From: ANDREW SEGGIE 
Sent: 27 May 2019 14:22
To: Planning
Subject: LU/126/19/PL objection to planning consent

I wish to lodge my objection to the development listed for planning consent covering 25 River Road and the frontage of Terminus Place

PROPOSED DRAWINGS:
Terminus Place
Proposed & Existing Street Scenes

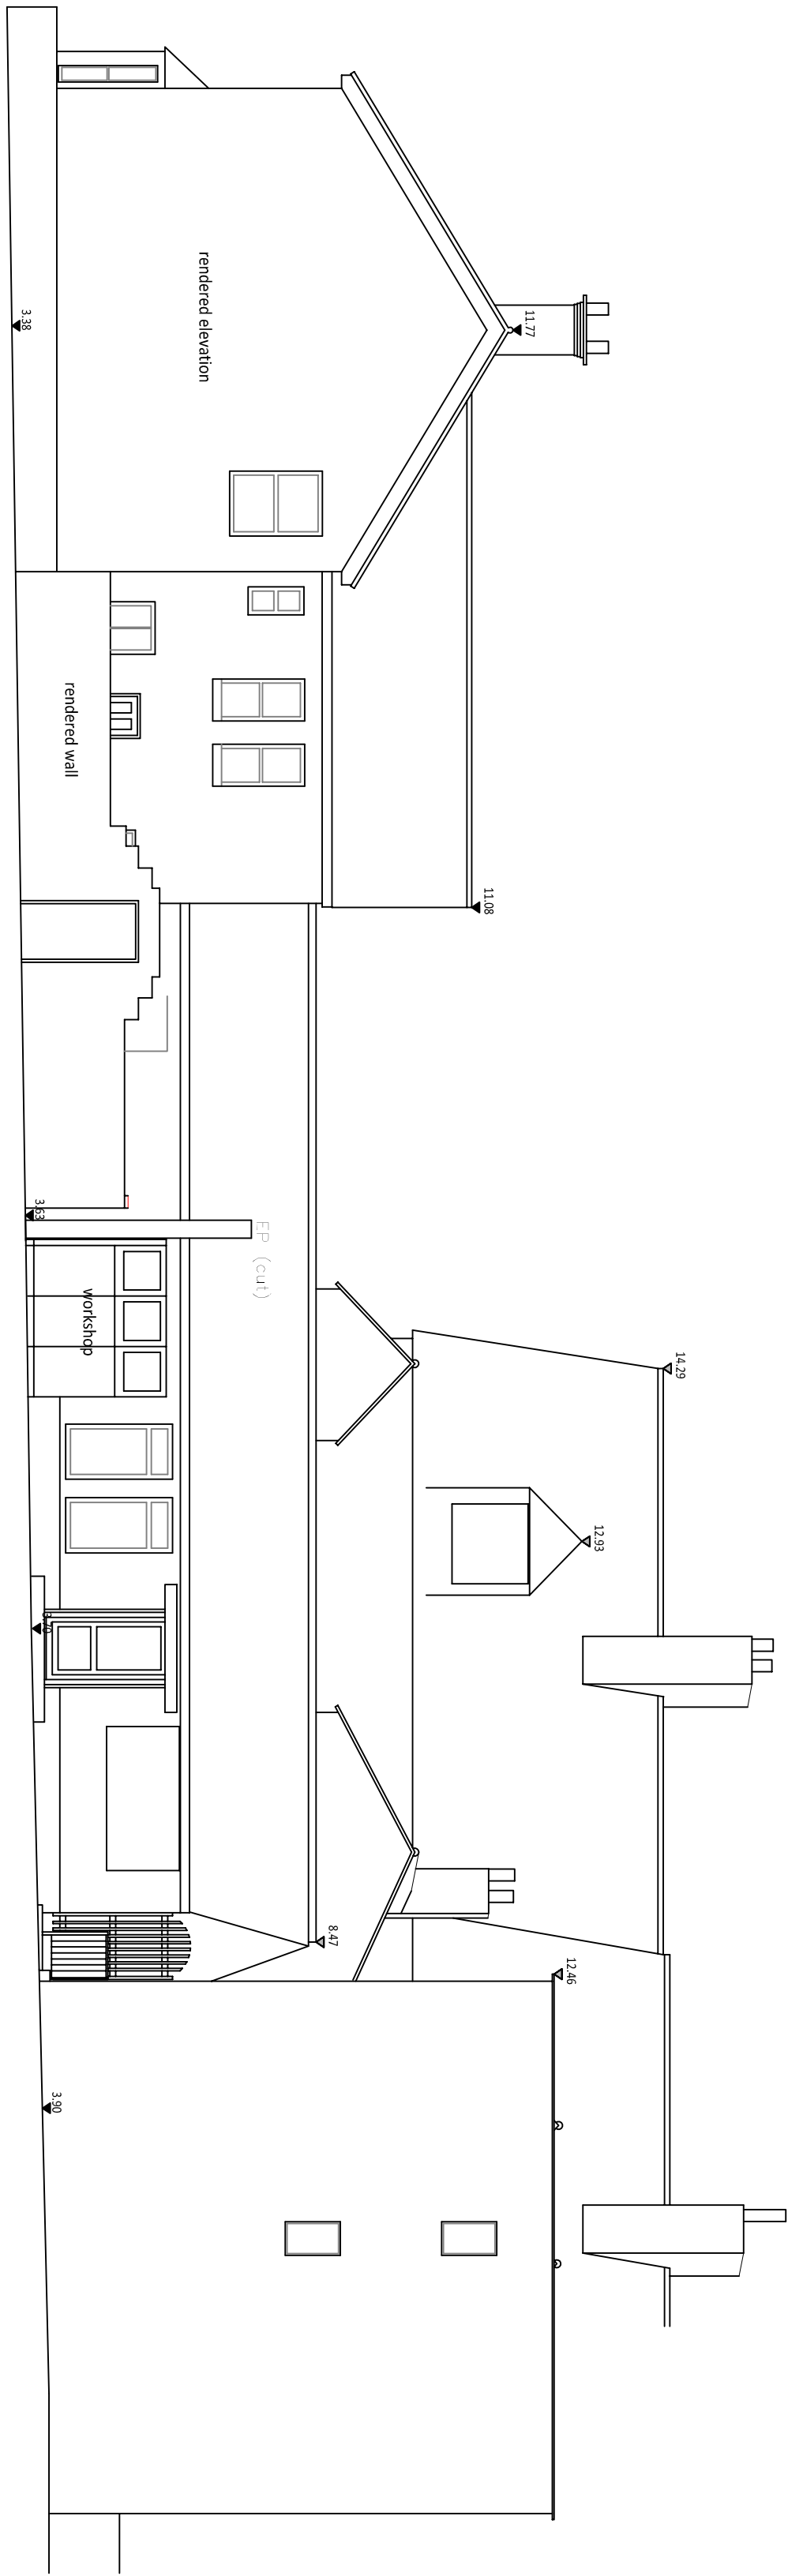
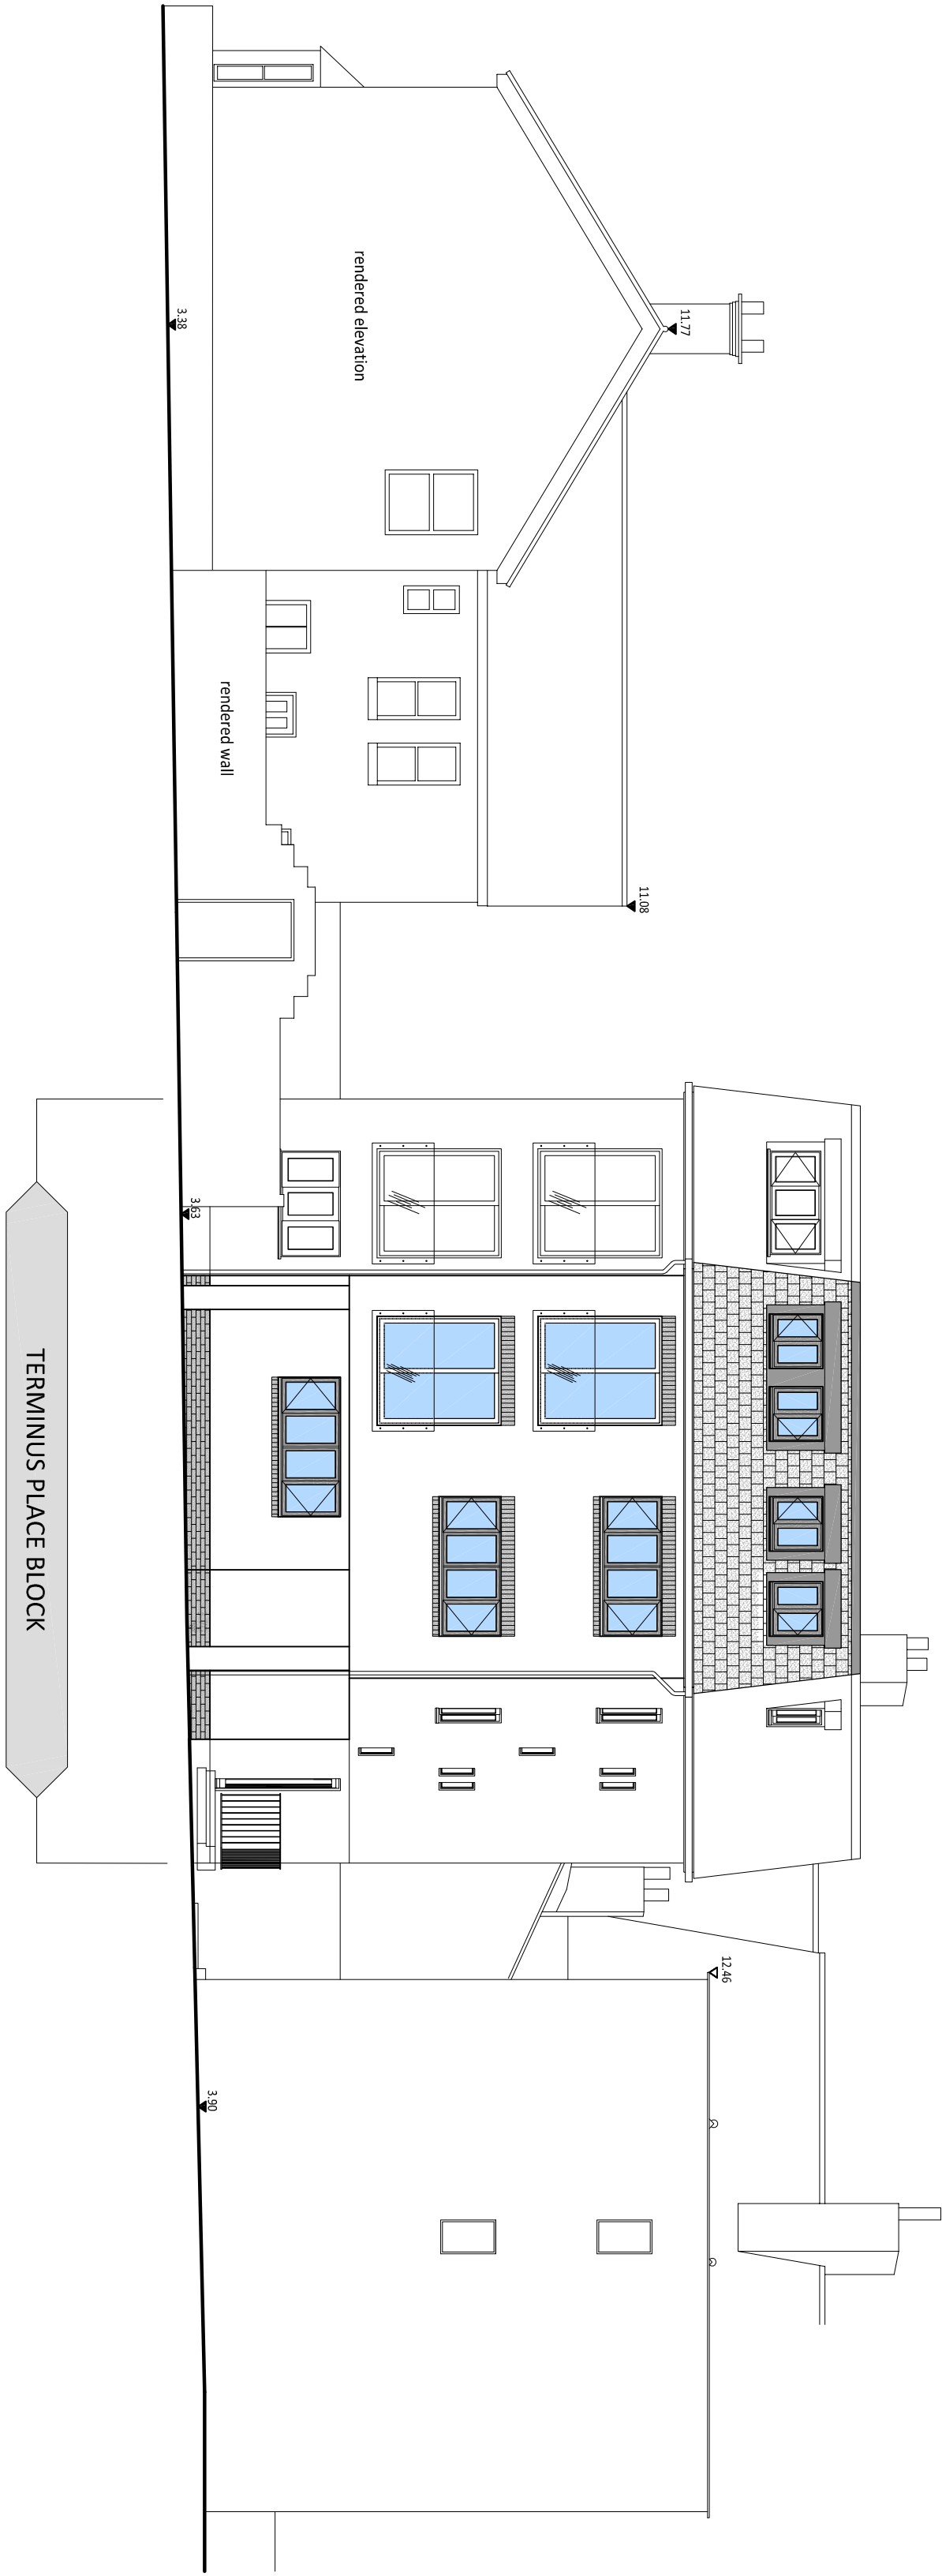
3a The height of the development is over 1 third higher than existing properties North - , East and south of it see pic 1 for current street view and building heights

There is significant impact to properties in the block north of the development- shown in Pic 1 , due to the light being blocked due to their aspect and the scale of the development
